From: Carla Thompson [<mailto:Carla.Thompson@Brown-co.com>]
Sent: 15 June 2015 09:21
To: A14 Cambridge to Huntingdon
Cc: robert.lenton@farmline.com
Subject: TR 010018 - 10030881 Mr R S Lenton Representation No 487 Deadline 2 Representations

TR 010018 - 10030881

Deadline 2 Representations

A14 Cambridge to Huntingdon Improvement Scheme

Drawing title: **RIGHTS OF WAY & ACCESS PLANS REGULATIONS 5(2)(k) & 5(2)(c) SHEET 10 OF 28**

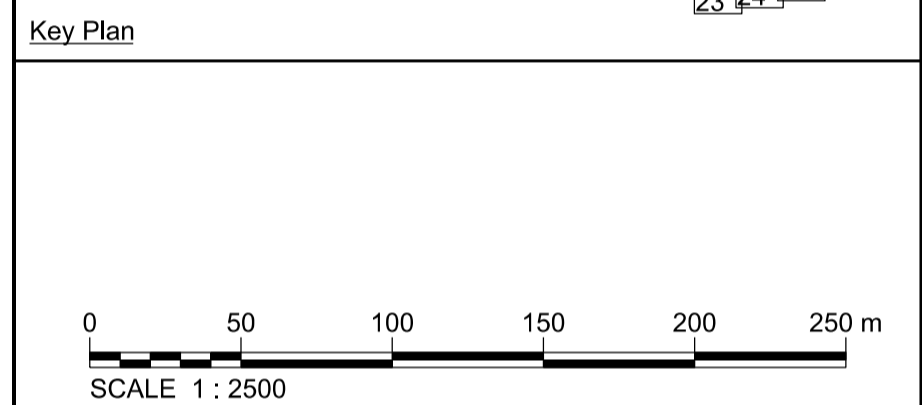
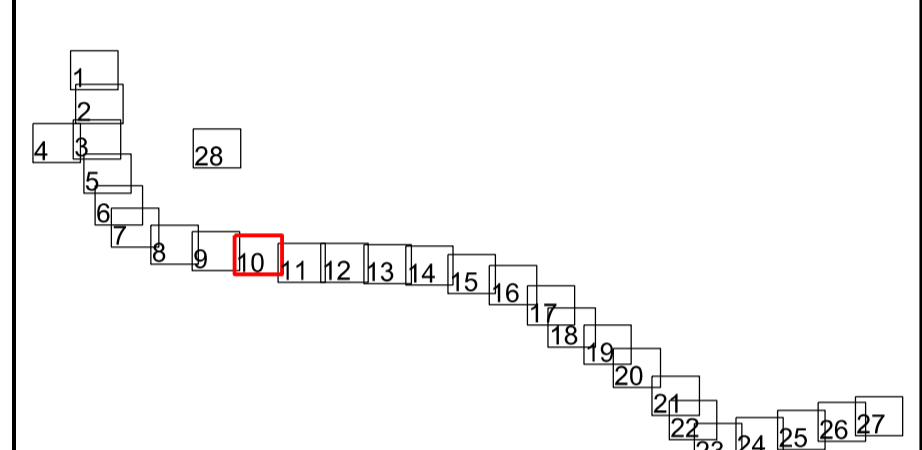
3. Our client has noted with concern the intention for temporary and permanent access rights to be acquired over plots 9/6, 9/11 and 9/14. In respect of plots 9/14 and 9/11 the configuration of the roadway conflicts with the farm premises and in particular plot 9/11 runs for much of its length through a permanent pasture field with evidence of ridge and furrow to the rear of the farmstead. There is currently no track or access through this field and the creation of such tract and future maintenance of the same is an on-going concern to our client.

4. The effect of the scheme will be to serve land south of plot 10/7a from the balance of Corpus Christi Farm. Access will be provided from the Corpus Christi Accommodation Bridge, General Arrangement Sheet8. Currently no access has been provided to our clients severed land south of the road (see also Rights of Way and Access Plan Sheet 9).

5. Our client notes that access to the Accommodation Bridge on the north side and potentially on the south side is via a ramped access road (plot 10/7c), it is essential that access to the over bridge should be safe and suitable for farm machinery and in particular should be will designed and adequate turning circles.
